SEPA MITIGATED DETERMINATION OF NONSIGNIFICANCE

- Project:** Graham Rezone (Z-08-02) and Graham Family Short Plat (SP-08-02)
- Description:** A rezone from Forest & Range to Rural-3 together with a Short Plat to subdivide approximately 12.19 acres of land into four (4) lots.
- Proponent:** Richard Graham
PO Box 1026
Cle Elum, WA 98922
- Location:** The project is located south of Interstate 90, off Lower Peoh Point Road, Cle Elum, WA 98922, and is located in a portion of Section 04, T19N, R16E, WM, in Kittitas County. Map number 19-16-04030-0013.
- Lead Agency:** Kittitas County Community Development Services

GRAHAM FAMILY SHORT PLAT SP-08-02 PORTION OF SW 1/4 OF SECTION 4, TOWNSHIP 19 NORTH, RANGE 16 EAST, W.M.

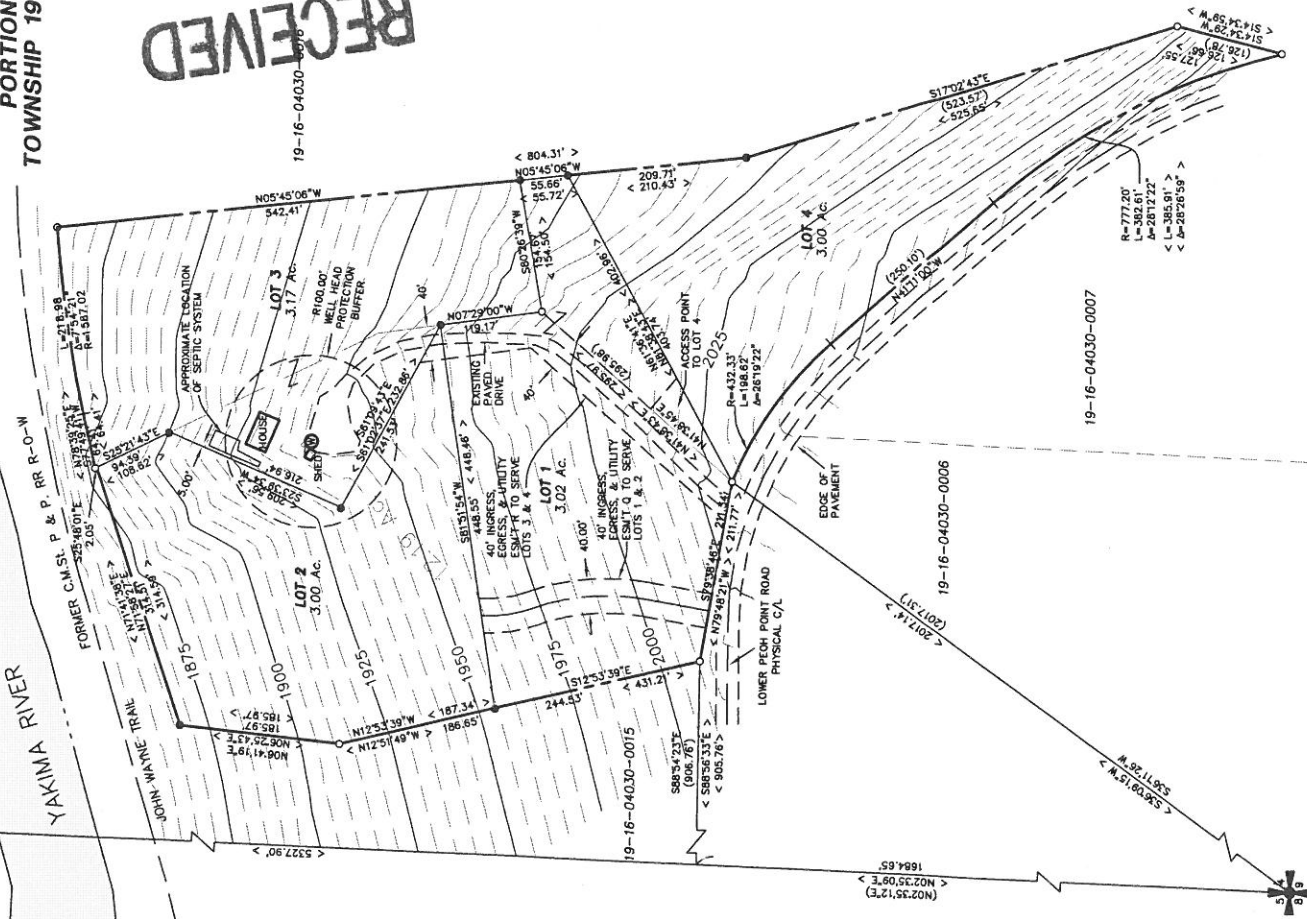
- A. The applicant shall be responsible for meeting or exceeding all conditions and requirements set forth by the Department of Public Works, as listed in the attached memorandum.
- B. A minimum 20' wide access and utility easement shall be shown on the final mylars for the proposed access location to Lot 4 of the Graham Family Short Plat.
